KIRKLEES METROPOLITAN COUNCIL

UPDATE OF LIST OF PLANNING APPLICATIONS TO BE DECIDED BY

10 AUGUST 2017

Planning Application 2017/91623

Proposed Site Plan

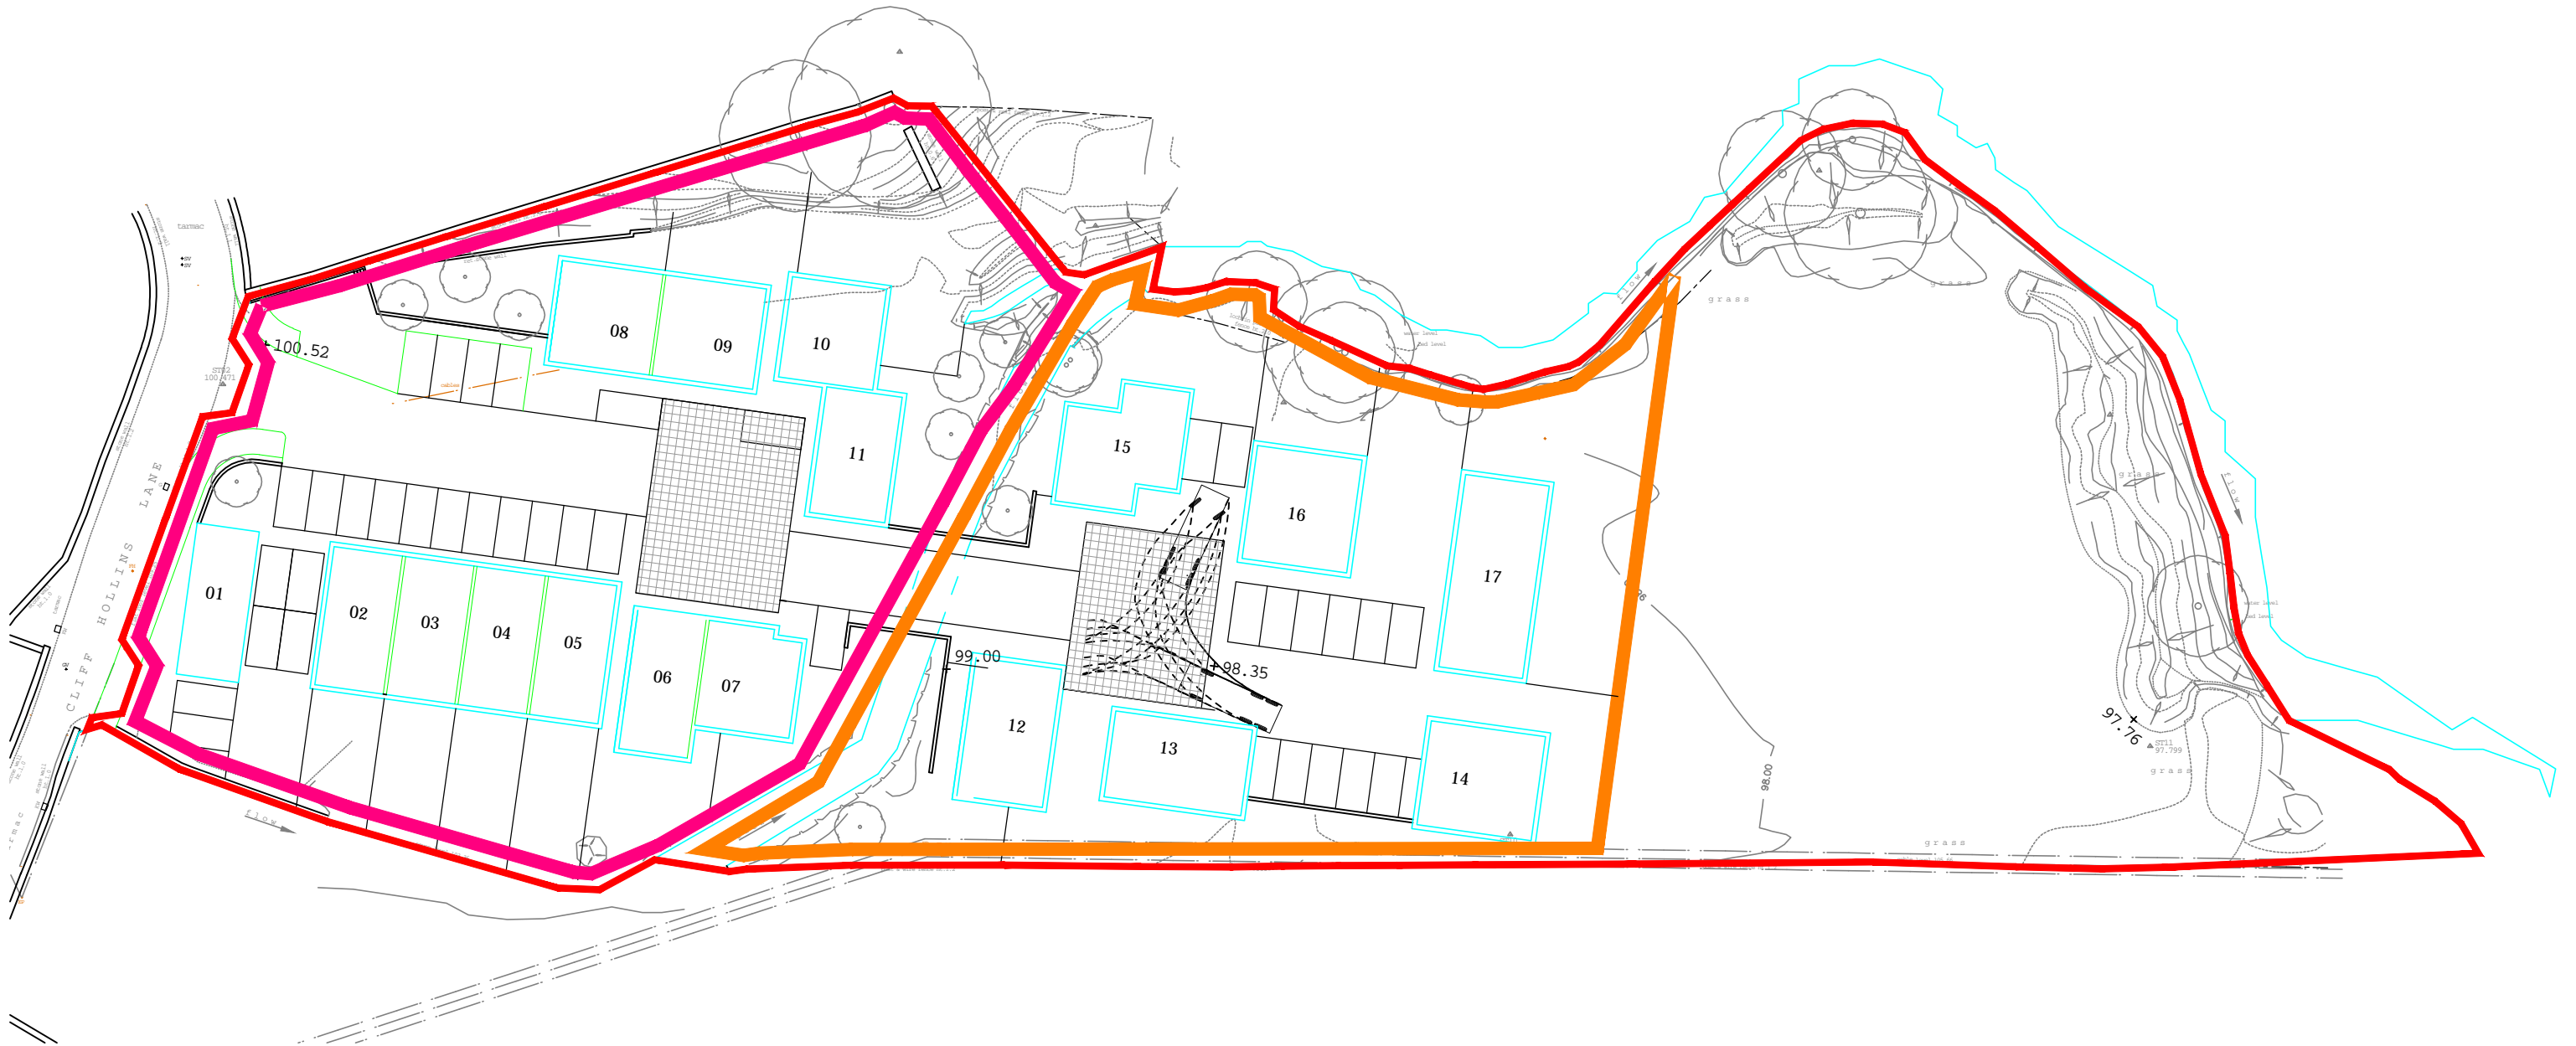
Details of the developable and undeveloped balance of the site will be submitted at Reserved Matters to accord with proposed site plan PL-003 Rev.

Any existing buildings/ structures located outside of the developable area shall be removed from the site and the land landscaped accordingly.
